RE: Sevilla @ Andalusia - (File: F11D015C)
Drainage Management Plan, Engineer's Stamp Date 12-19-2014
Grading and Drainage Plans, Engineer's Stamp Date 12-18-2014

Based upon the information provided in your submittals received 12-19-14, the above referenced submittals cannot be approved Preliminary Plat and Site Plan for Subdivision action by the DRB until the following comments are addressed.

**EXHIBIT 6**  
**GRADING PLAN**

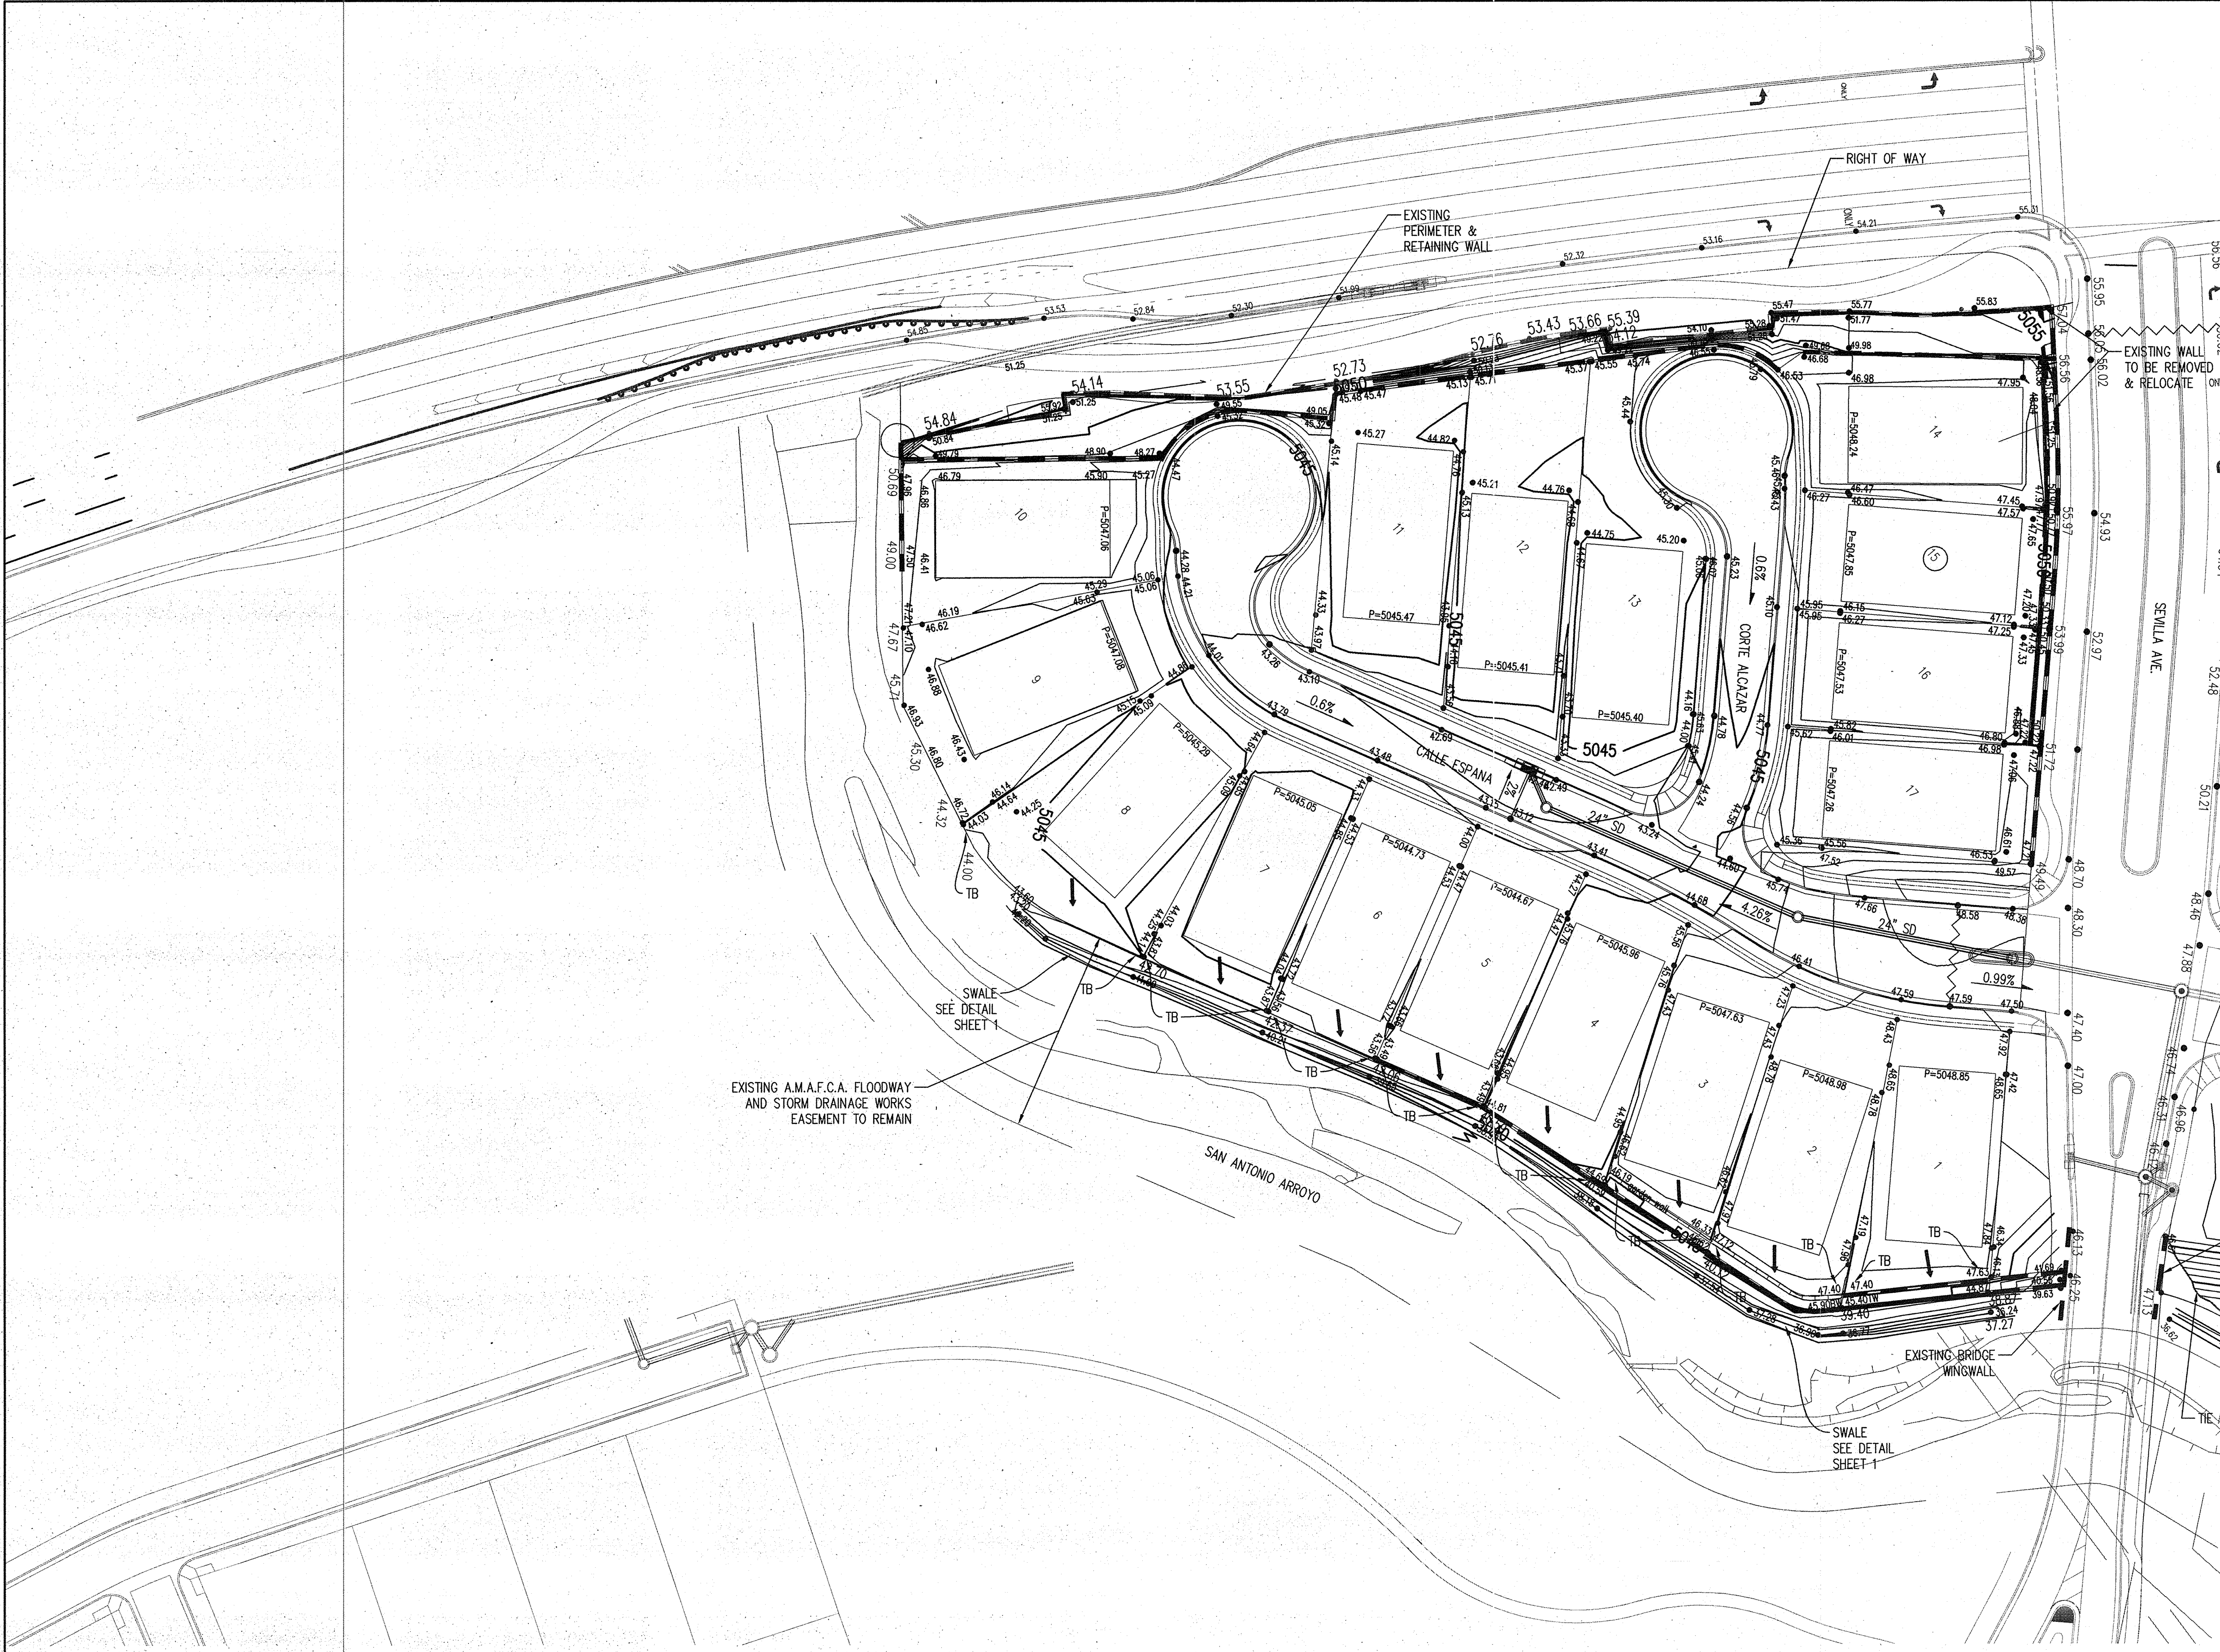
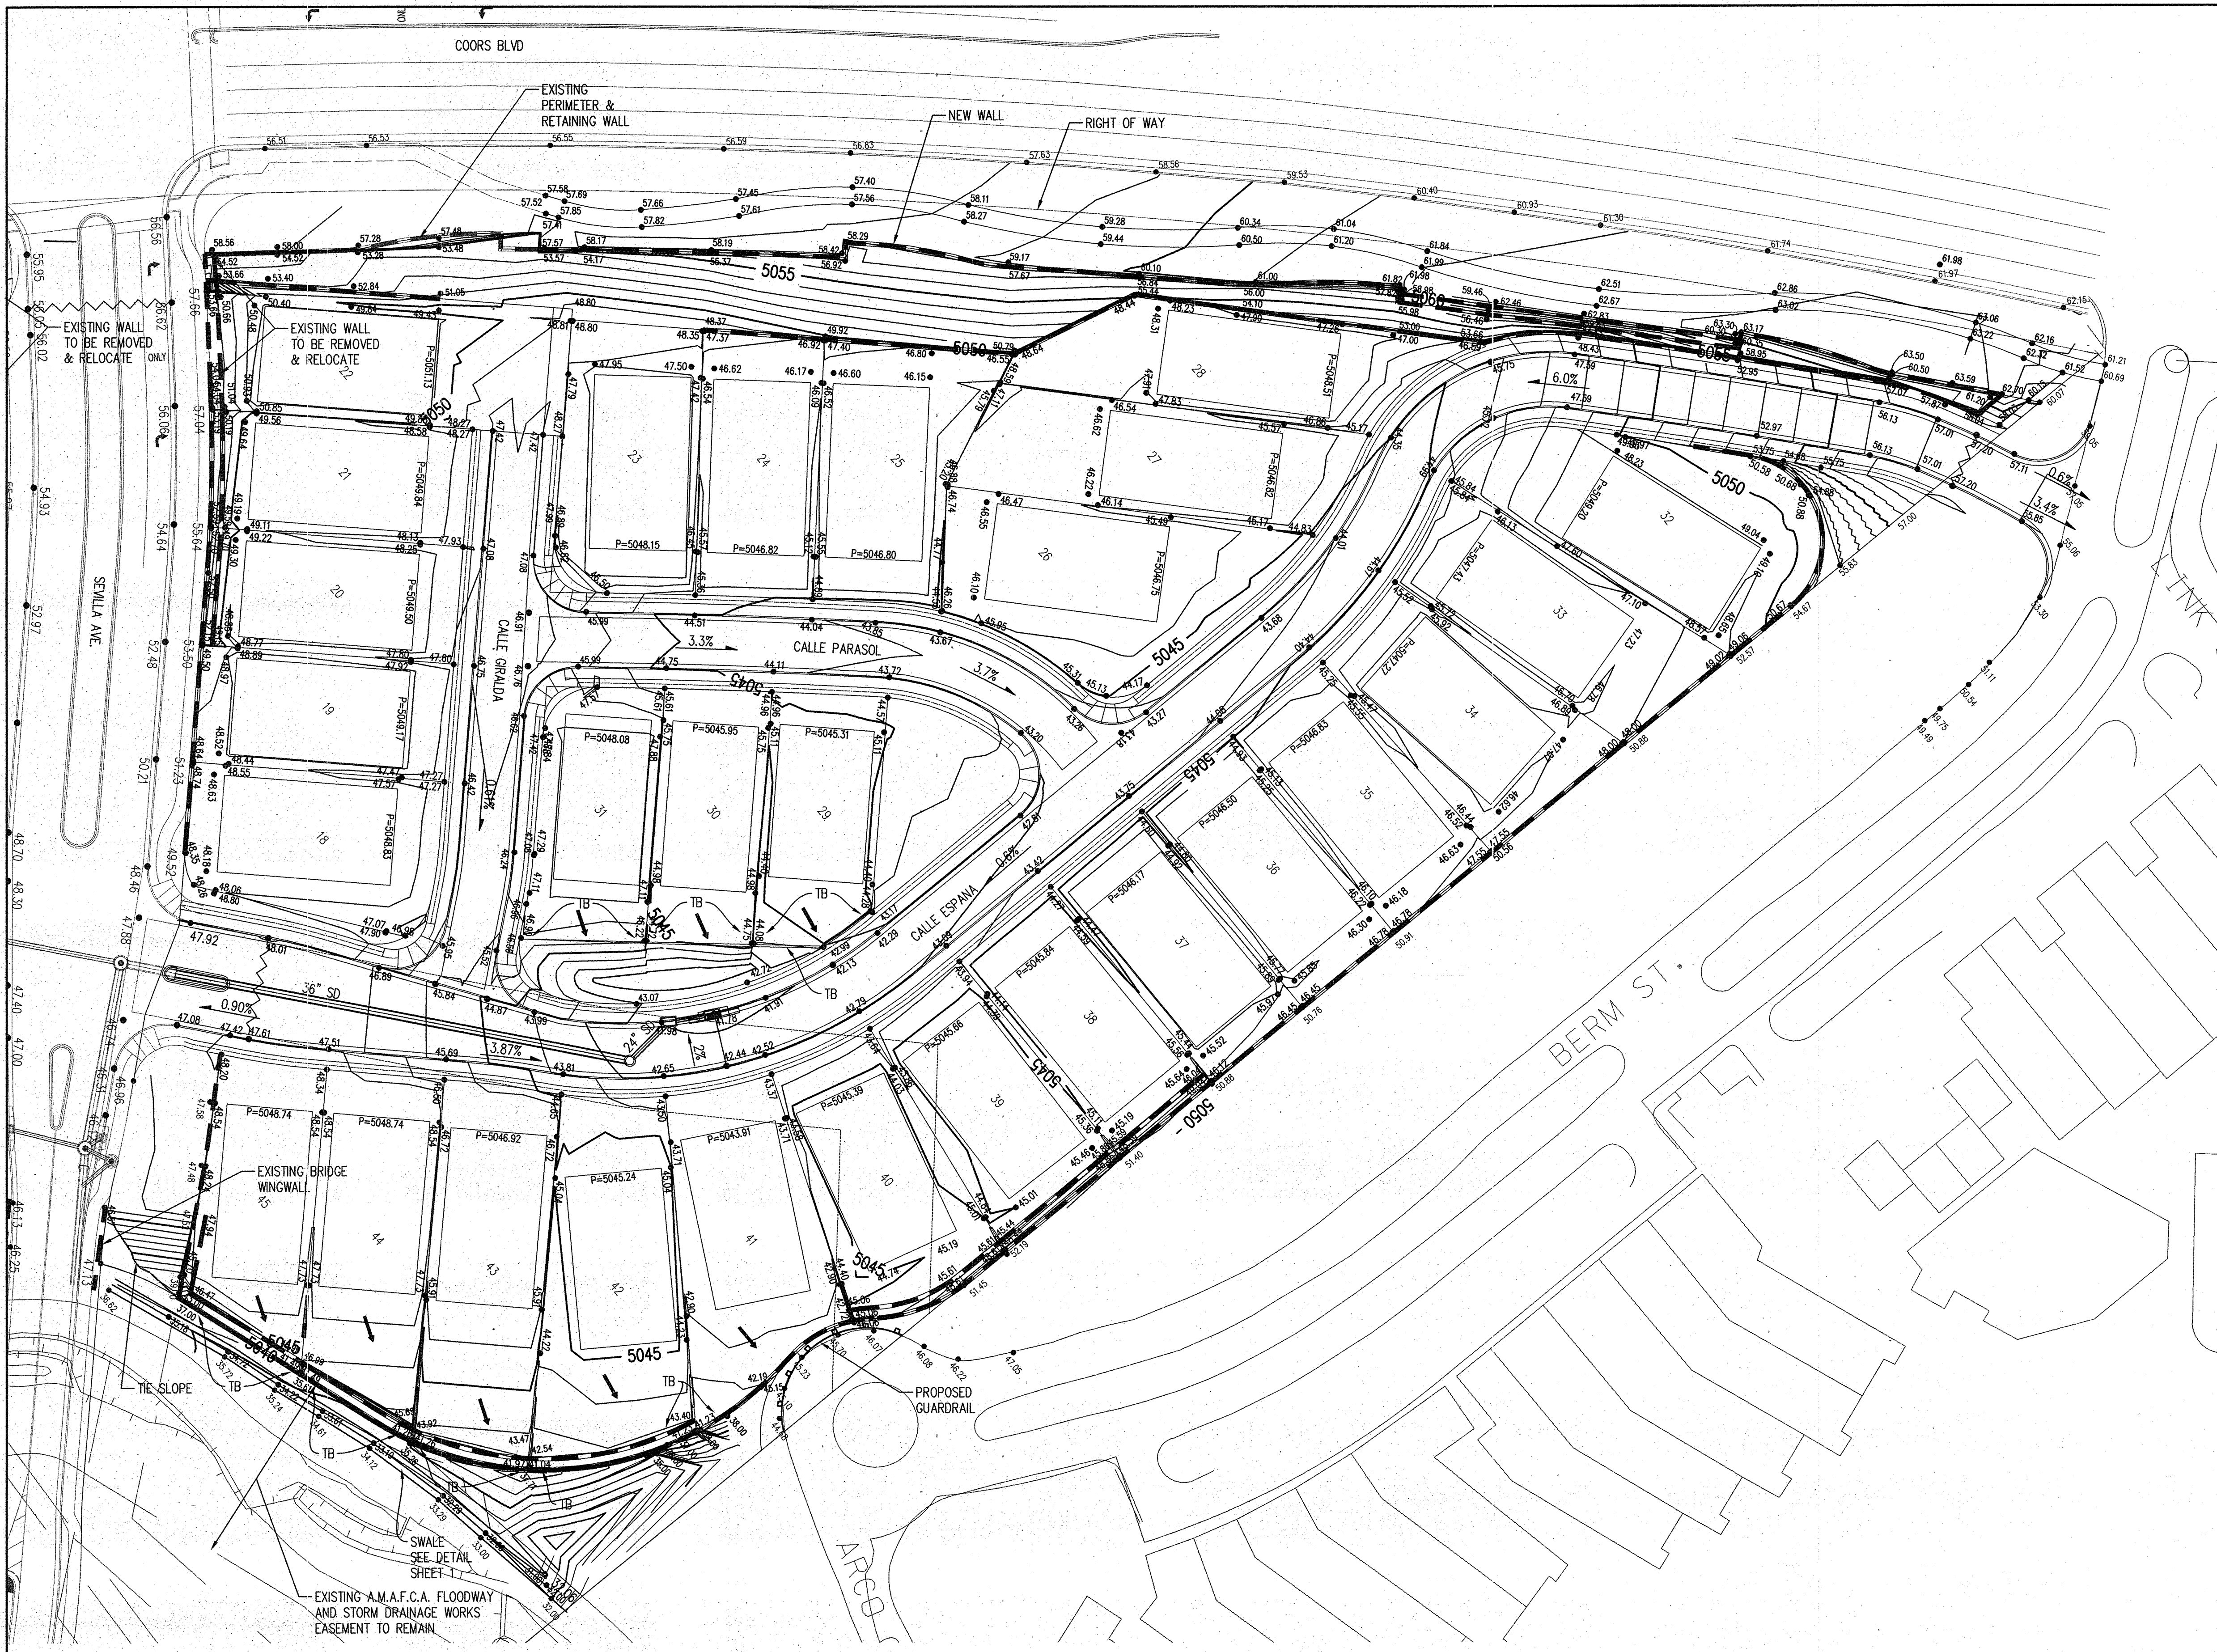
8. The contours, elevations and line work showing Coors Blvd, the curb and gutter are unclear.
9. Do flows on East side of Coors (in meandering sidewalk area) drain to this site? Particularly north of Sevilla Ave? The developed basin map shows flow arrows pointing west, but the contours do not support this. There seems to be some ponding in this area. Where is the R.O.W.? Where is the property line? How does this area drain?

10. Is the Retaining wall along Coors existing or proposed? Are both walls shown retaining walls? Site Plan for Subdivision suggests that the wall closer to wall is a decorative wall.

11. How do Open space tracts drain? Particularly the larger ones such as Basins D-E and H?
12. Show proposed contours.
13. Show top and bottom of wall elevations on Retaining walls on Grading Plan.

18. Show on the Grading Plan the earth lined swales that Basins B and F and K drain to as indicated in the report.
19. Indicate location and opening area of "Turned blocks" on the grading plan.

20. Clearly show AMAFCA Floodway and easements as well as the boundary of the SFHA A flood zone.
21. Show slopes of roadway on Grading Plan
22. Provide Road cross sections.

23. Indicate on the Grading plan where standard curb and mountable curb will be used.
24. Sump in north side (Tract B-2) shows 2 inlets on the Storm Drain Network map, but only 1 inlet on the Grading Plan. The report states that a double grate inlet will be used, but is not indicted elsewhere. Further, the Calculations state that the required capacity is 26.8 cfs, but the Allowable Capacity is for one inlet is 14.5 cfs. Similar comment is for the sump inlet in the south side (Tract A-1-A).

25. At sump in north side (Tract B-2), flowline elevations indicate that the road is superelevated. Provide street capacity calculations showing the superelevated street has capacity.
